Planning Application No: 3/2025/0223
Grid Ref: 374321 442337
Proposal: Proposed two-storey extension to side.
Location: 21 Park Avenue Clitheroe BB7 2HP

Tahira Akhtar BA (Hons)
Technician
Highway Development Control
Highways & Transport
Lancashire County Council

PROPOSED GROUND FLOOR PLAN
SCALE 1:50

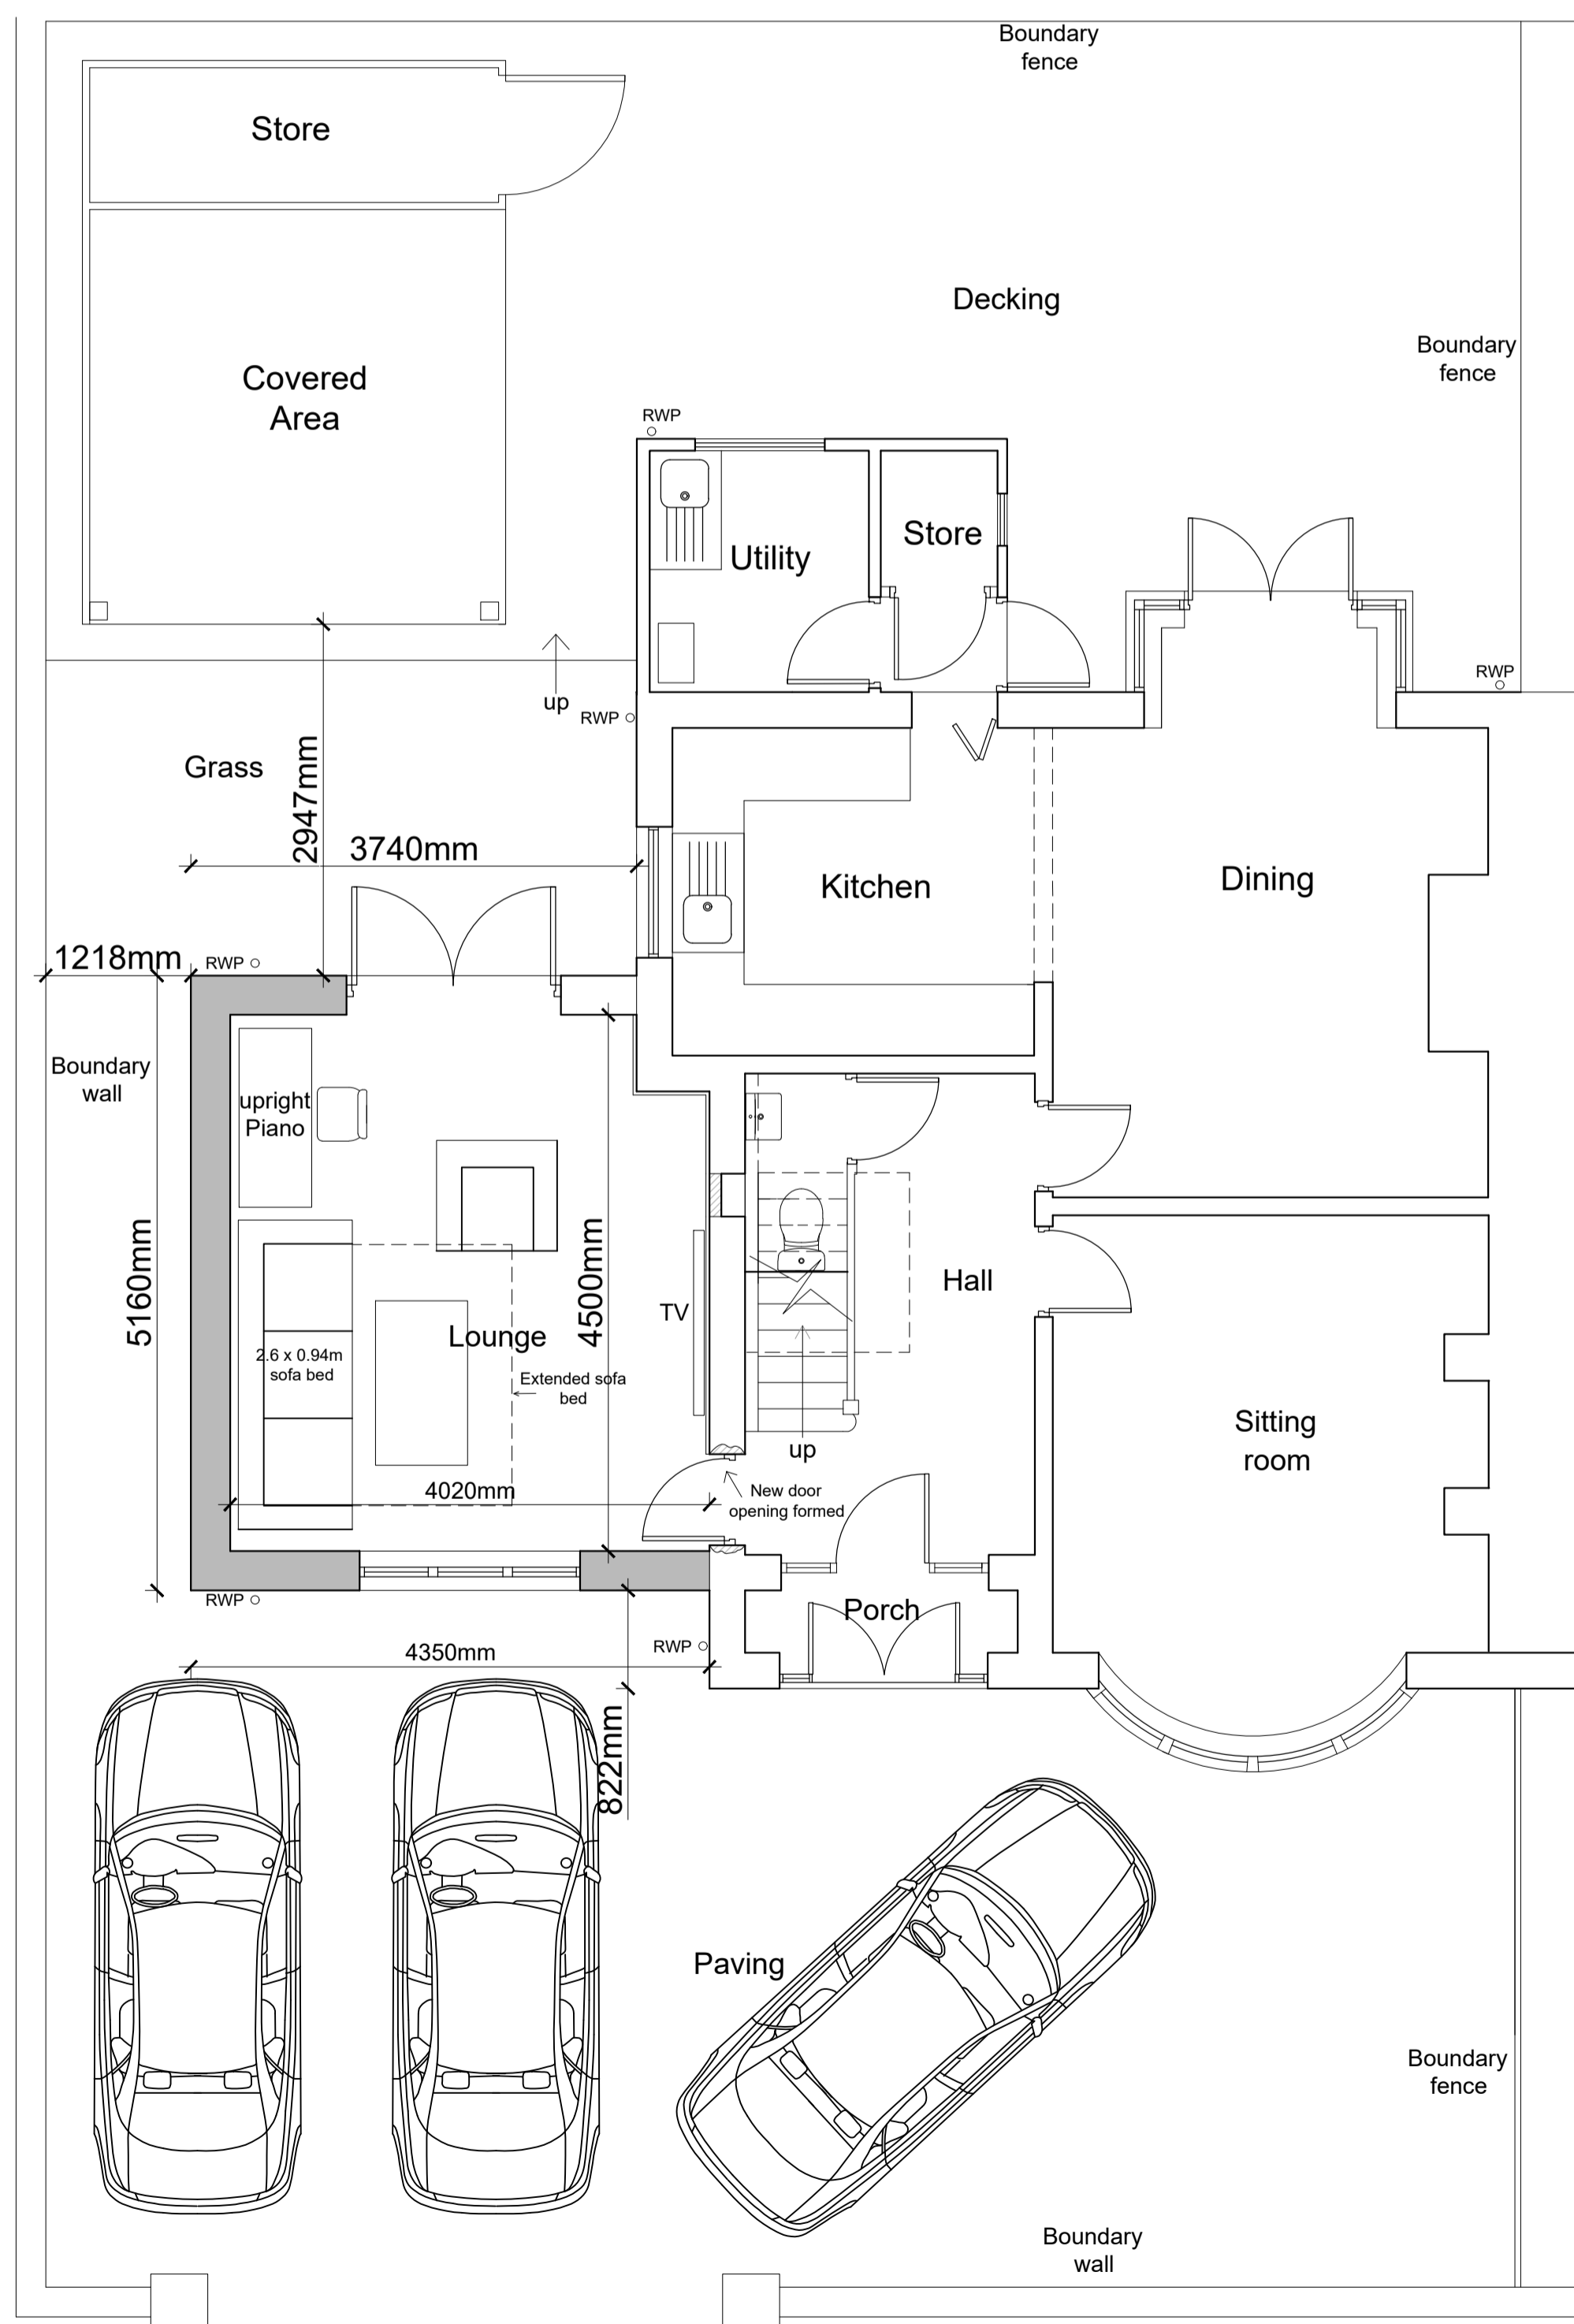
Proposed development is two storey side extension to the existing dwelling. There is an increase in the number of bedrooms from 3 to 4 with this proposal, therefore an increase in parking standard requirements. No parking plan has been provided. If the 3 parking spaces, as required by parking standards can be met within the curtilage of the property then there is no objection on highway grounds.
